# CITY OF ALBUQUERQUE

January 24, 2025

**Re: Coyote Gravel, Secondary Site**  
**Draft Traffic Impact Study (M14D041)**  
Engineer's Stamp DRAFT November 2024  
Via email: jroberts@tierrawestllc.com

The subject Traffic Impact Study (Study) draft received on December 13, 2024, has been reviewed by the City of Albuquerque Planning Development Transportation Section and provides the following comments.

SITE PLAN

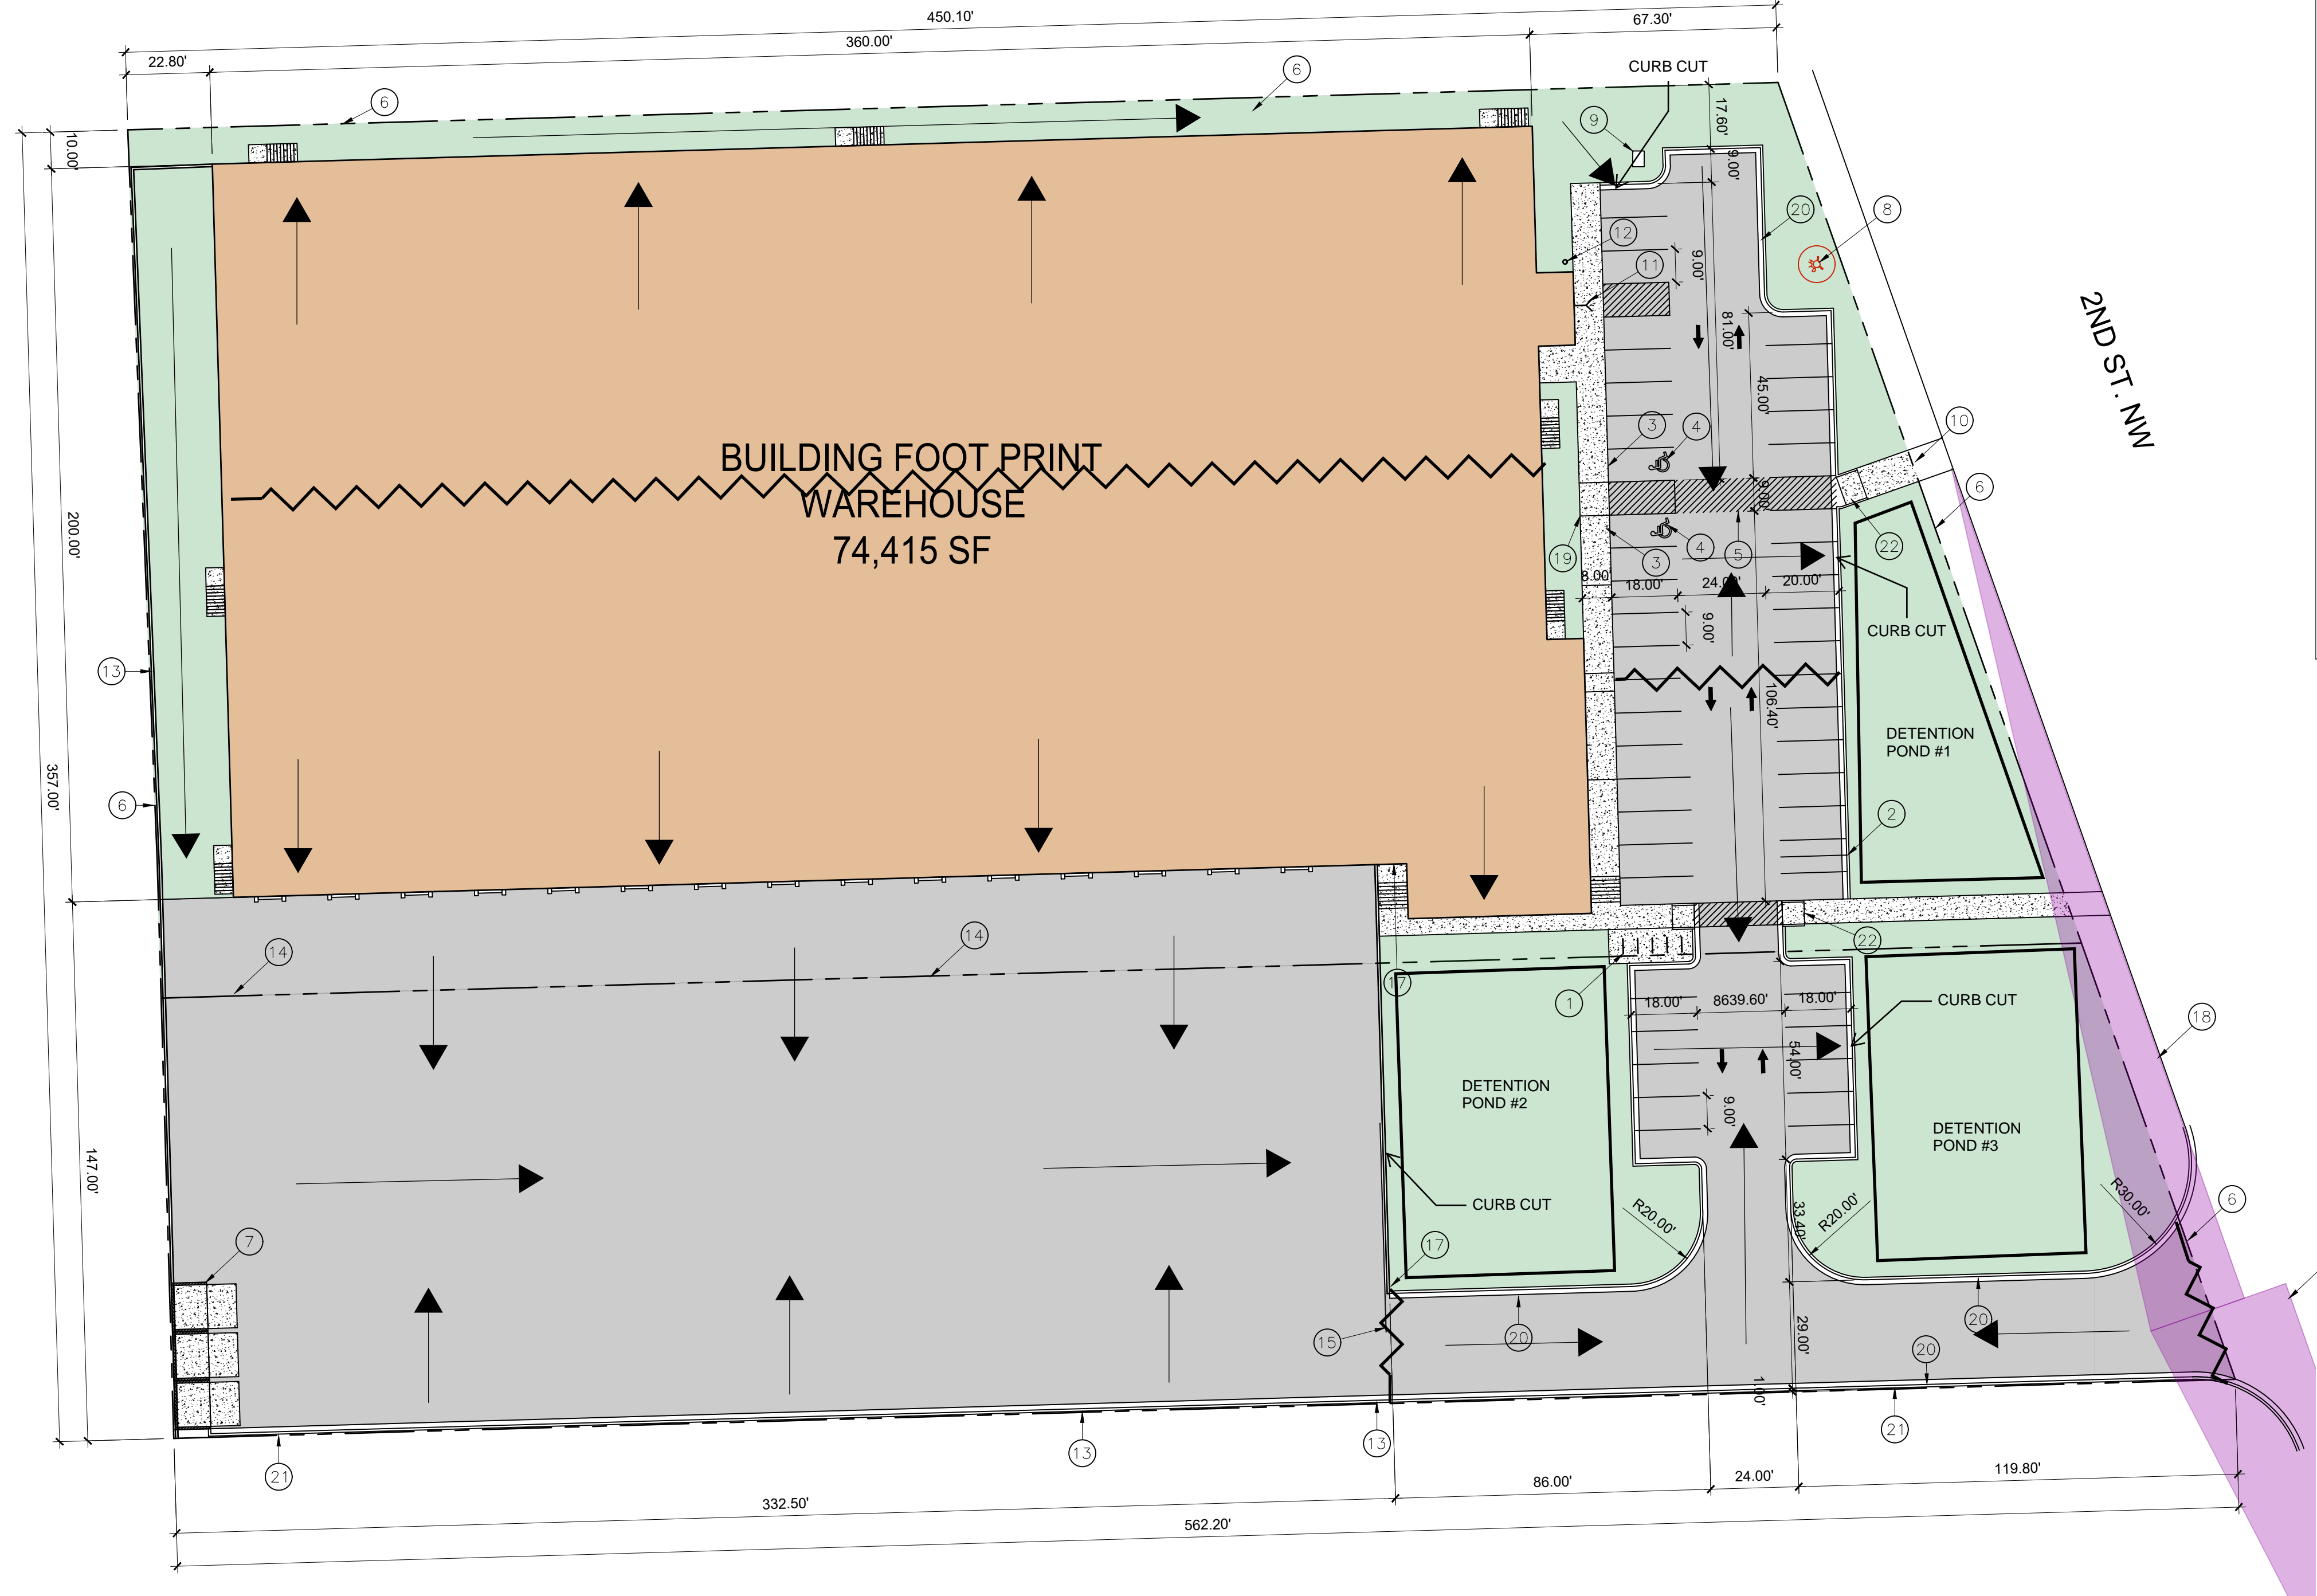
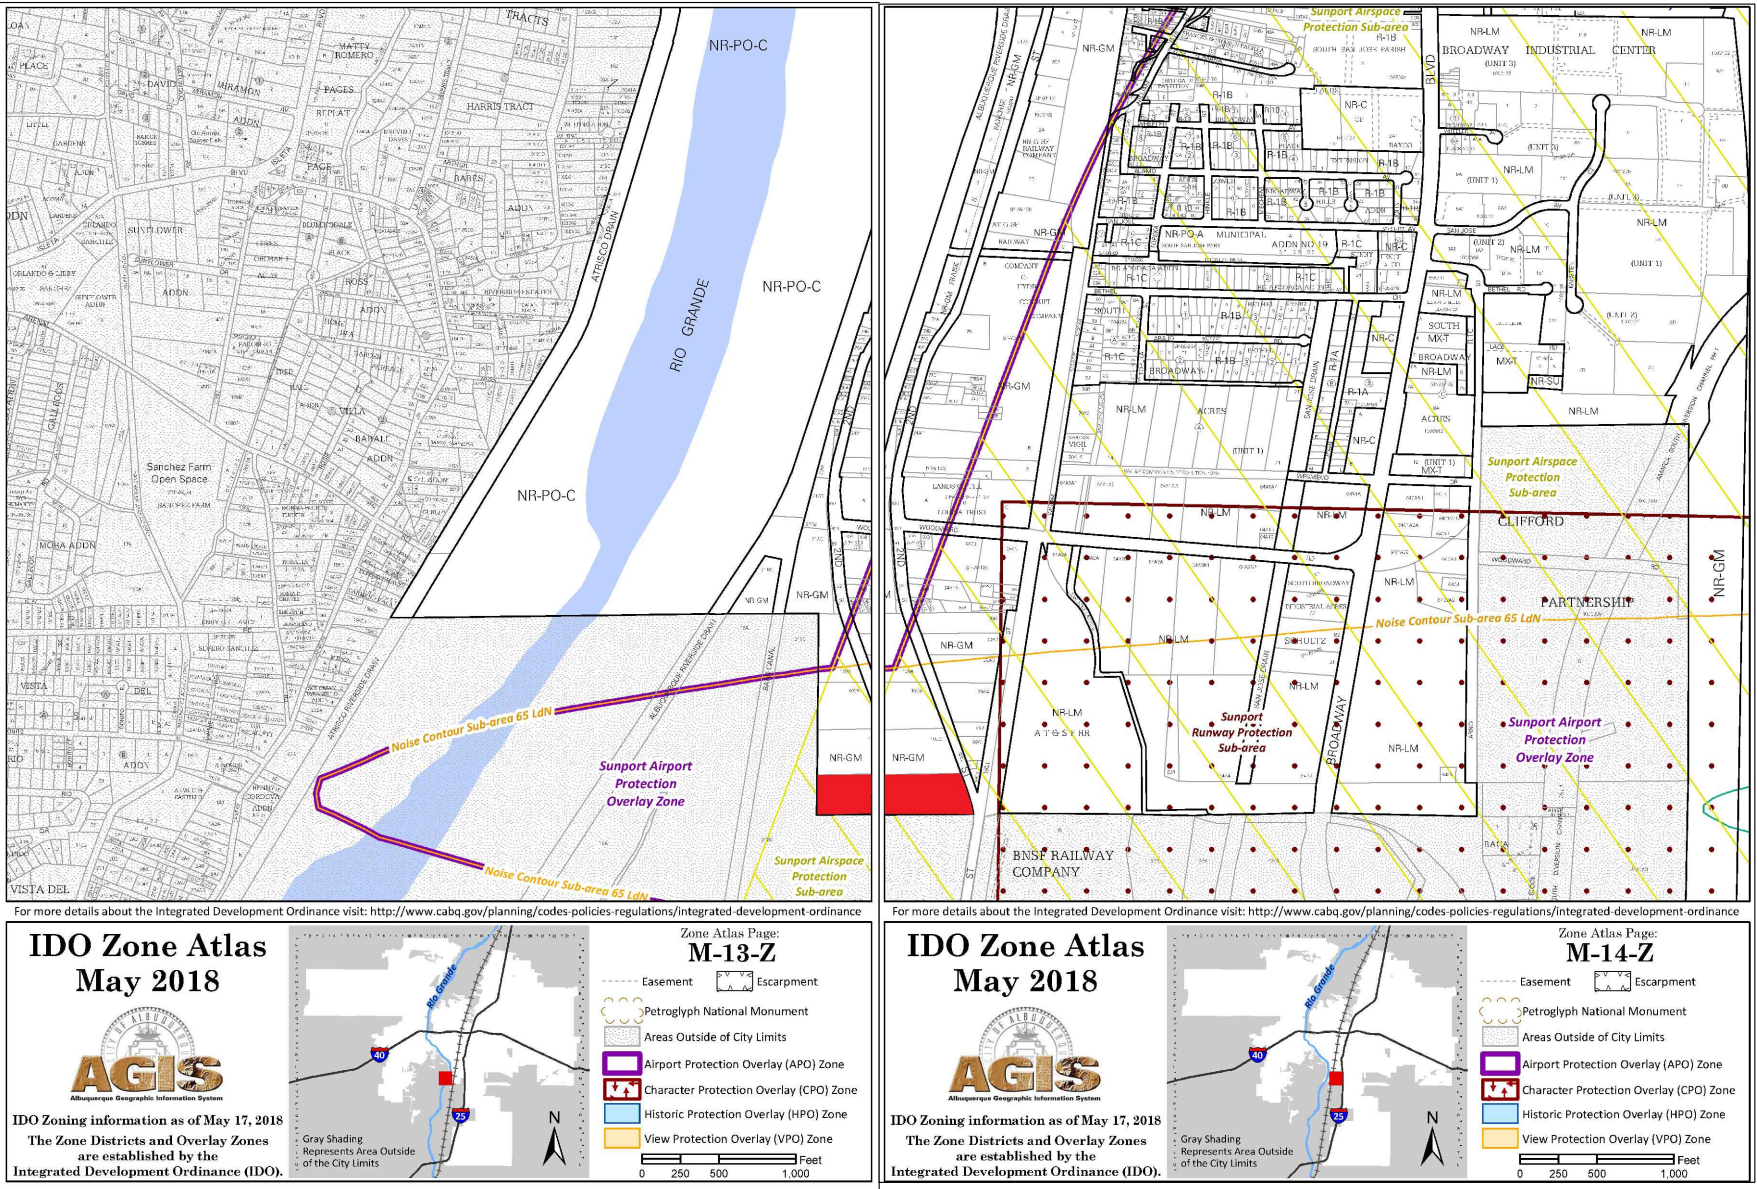
- d. The Site plan on page 5 shows the site straddling 2 lots. One lot would be outside City limits. How will you permit a project with a jurisdictional boundary down the middle?

- e. Site Access on p.8 provides a distance for Driveway A from Woodward Rd and for Driveway B from Rio Bravo Rd. How far are the driveways apart? Demonstrate on a Site plan.

Figure 2: Vicinity Map

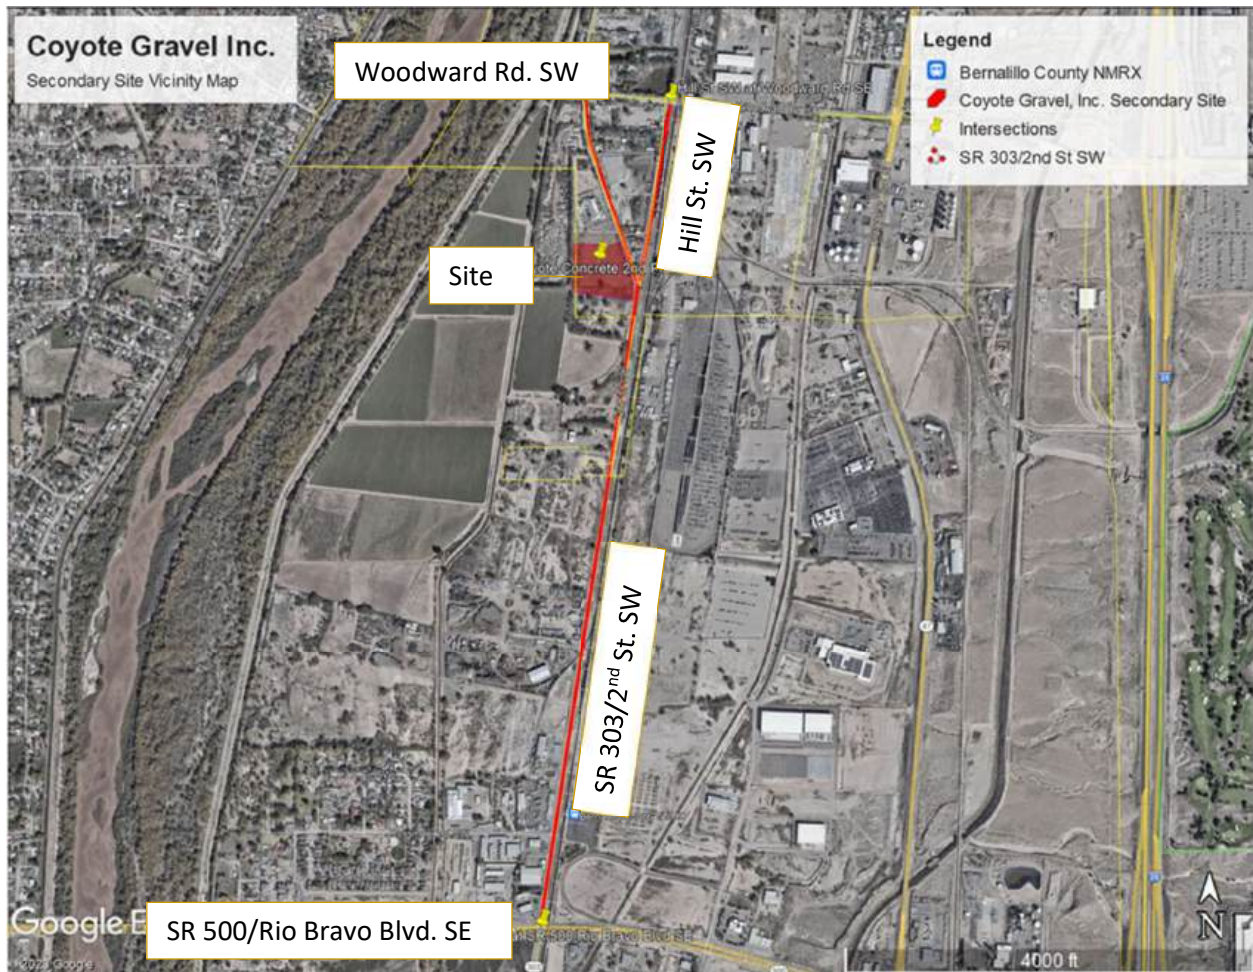
- b. The Vicinity map appears to show this project south of City Jurisdiction. Is some of the project outside City limits?
  - c. The DTIS states there are two lots of approx. 6 acres, while the Study states approximately 9.3 acres. BernCO database agrees with the approx.. 6 acres. Where are the other 3.3 acres coming from?

Table 3: Access Spacing Standards for Intersections and Driveways

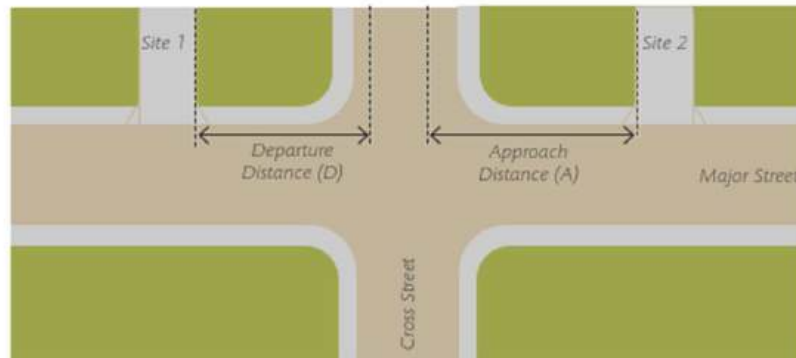
3. Access spacing analysis on p.8 states the driveways meets the access spacing standards but the spacing is not provided or shown.
